RE: PROJECT – PRELIMINARY PLAT - PR-2025-020092, VOLCANO CLIFFS UNIT 26

Compiled Sketch Plat Review Comments with Applicant Responses

CSI-CARTESIAN SURVEYS INC.
P.O. BOX 44414 RIO RANCHO, N.M. 87174
Phone (505) 896 - 3050 Fax (505) 891 - 0244
cartesianbrian@gmail.com
Sheet 2 of 4
251082

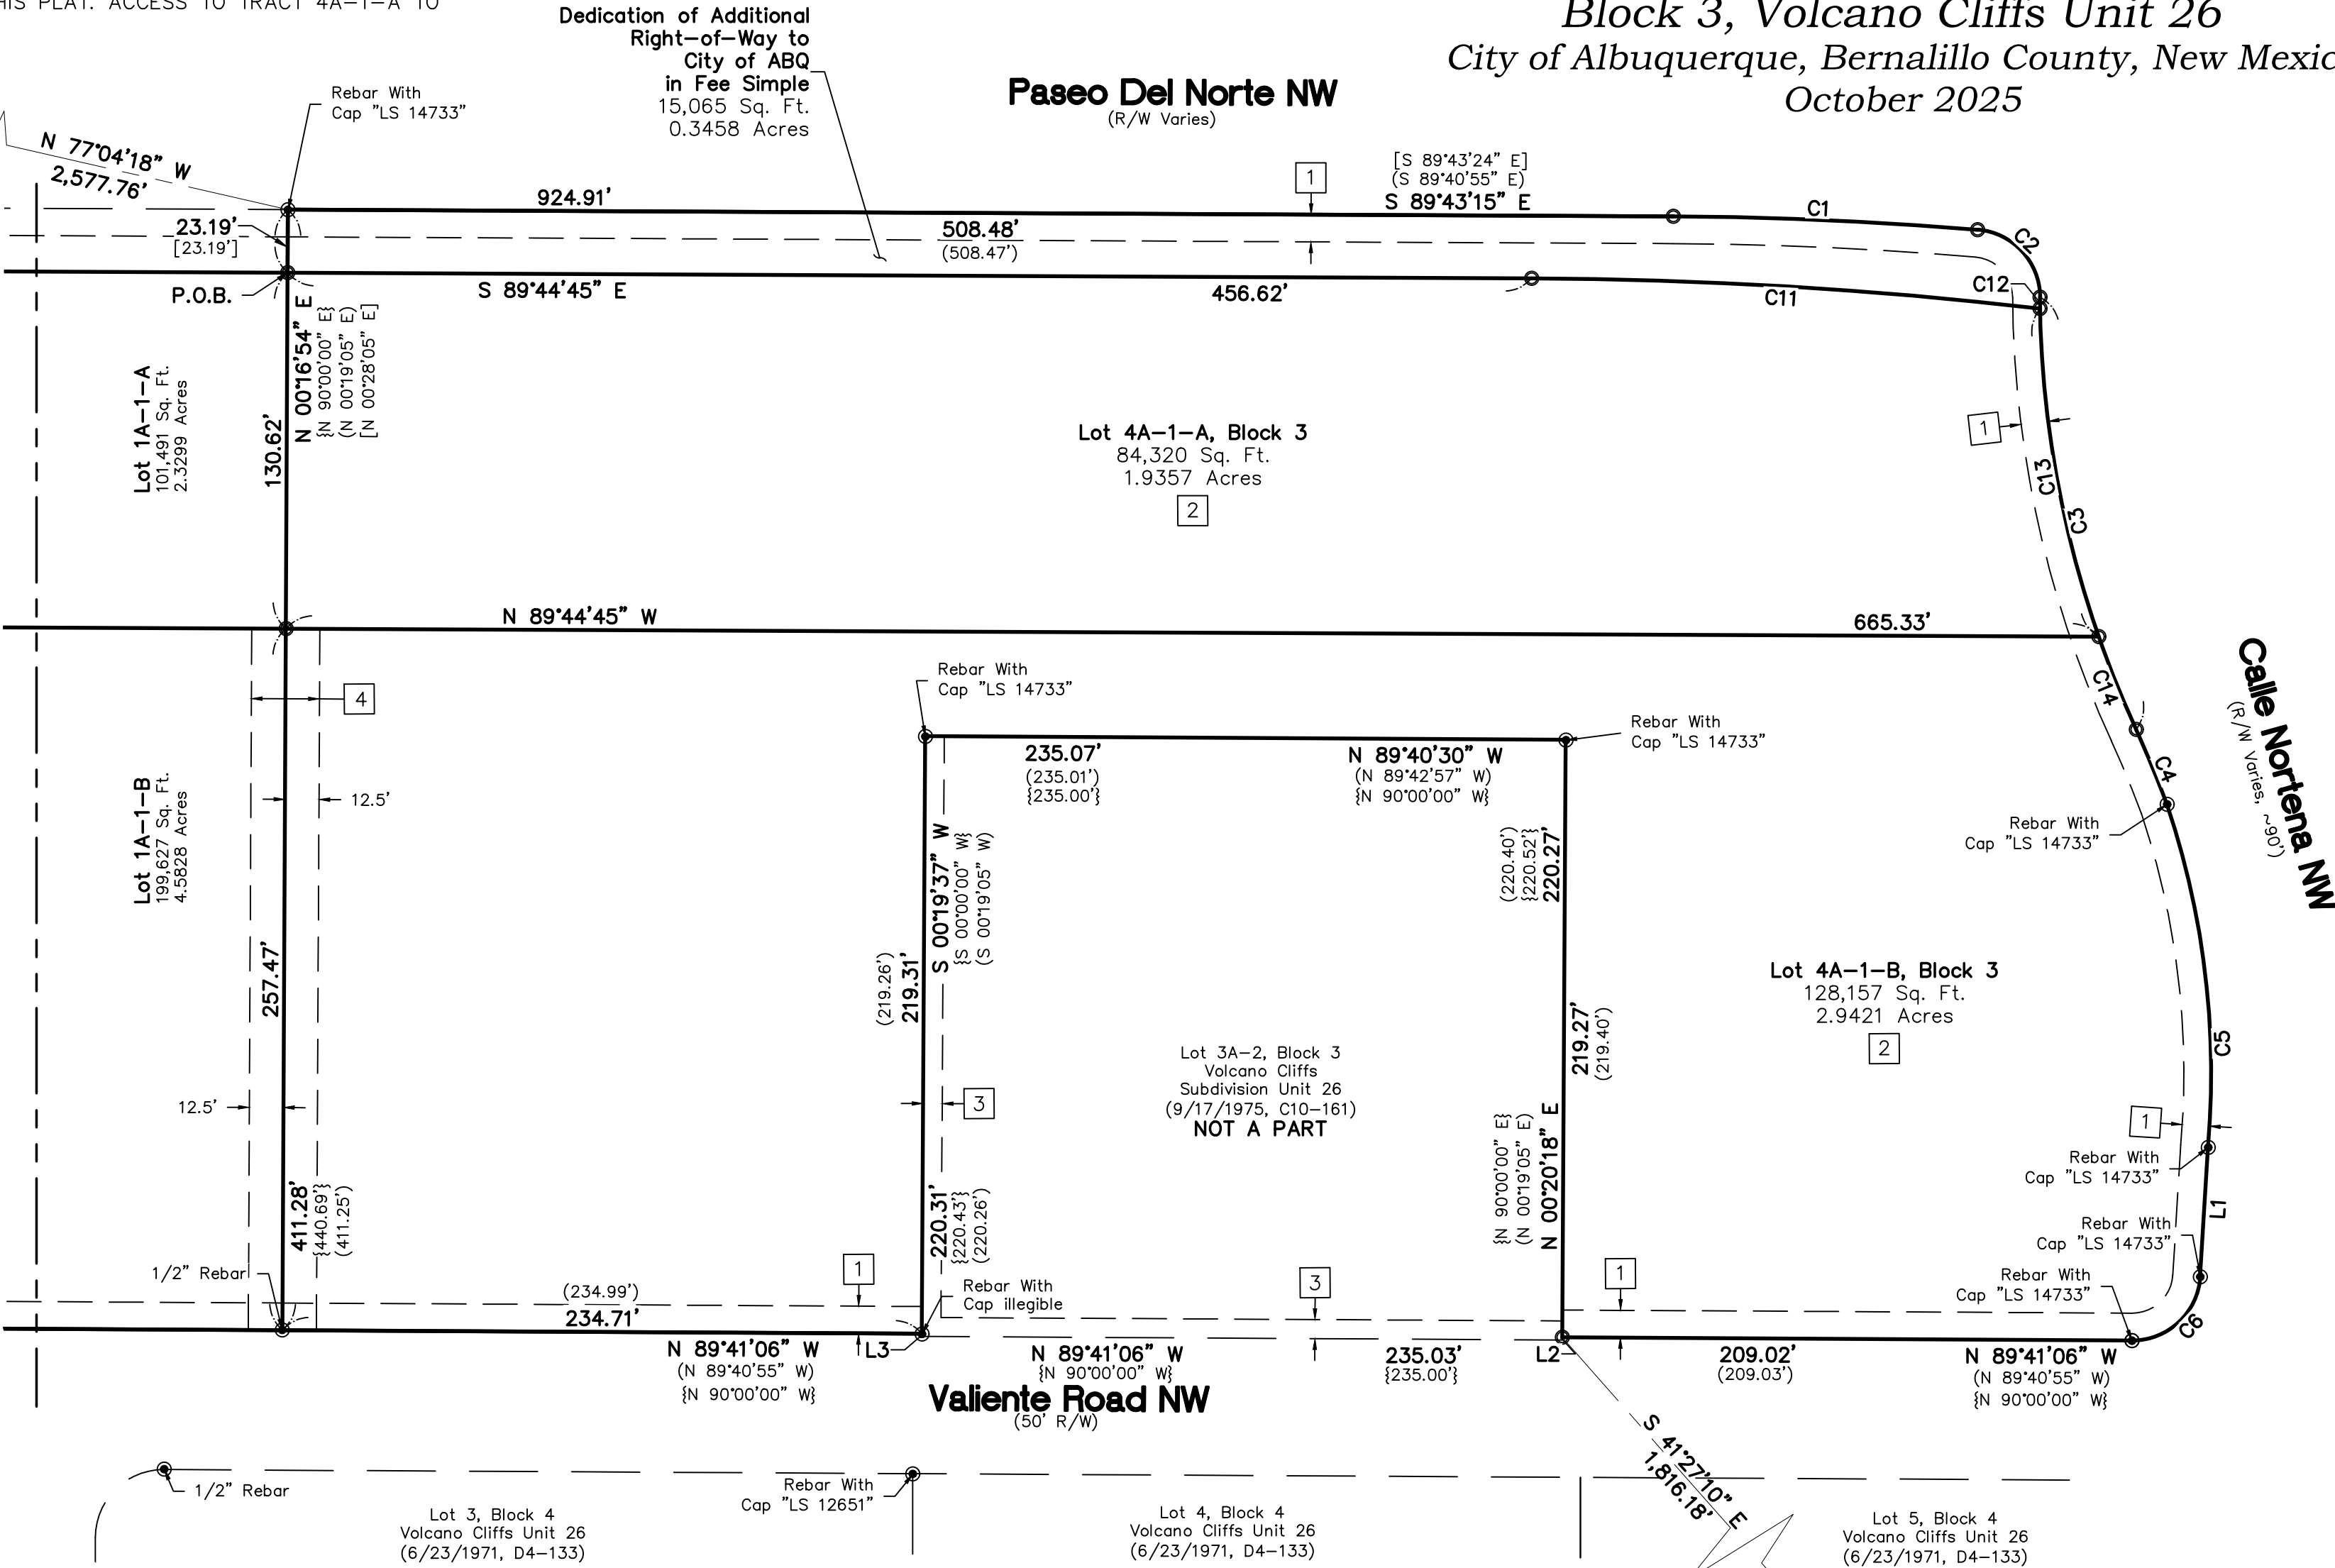
- Comment: As proposed, Lots 4A1A and 1A1A do not have all frontages with access to both water and sanitary sewer infrastructure.

- Comment: Exclusive public water and sanitary sewer easements are required for all public lines that are to be constructed outside of any dedicated rights-of-way. A minimum width easement of 20' is required for a single utility and 25' for water and sewer both within the same easement.

- Comment: The surveyor shall field verify the location of existing private water and/or private sanitary sewer services to determine if private service easements are needed.

- Comment: Proper private water and/or private sanitary sewer service easements shall be granted for access to public waterline and/or public sanitary sewer for proposed lots which do not have direct access.

Applicant Response: 4A-1-A will access water and sewer from Calle Norte road. 1A-1-A will access sewer from the new proposed 20' private sewer easement (Easement 4 on the plat). Water will be accessed off of Kimmick Road. Please see conceptual Utility plan for reference.

Applicant Response: A new proposed 20' private sewer easement (Easement 4 on the plat) will be granted with this plat.

Applicant Response: Completed and a new proposed 20' private sewer easement (Easement 4 on the plat) is being proposed on this plat.

Applicant Response: 4A-1-A will access water and sewer from Calle Norte road. 1A-1-A will access sewer from the new proposed 20' private sewer easement (Easement 4 on the plat). Water will be accessed off of Kimmick Road. Please see conceptual Utility plan for reference.
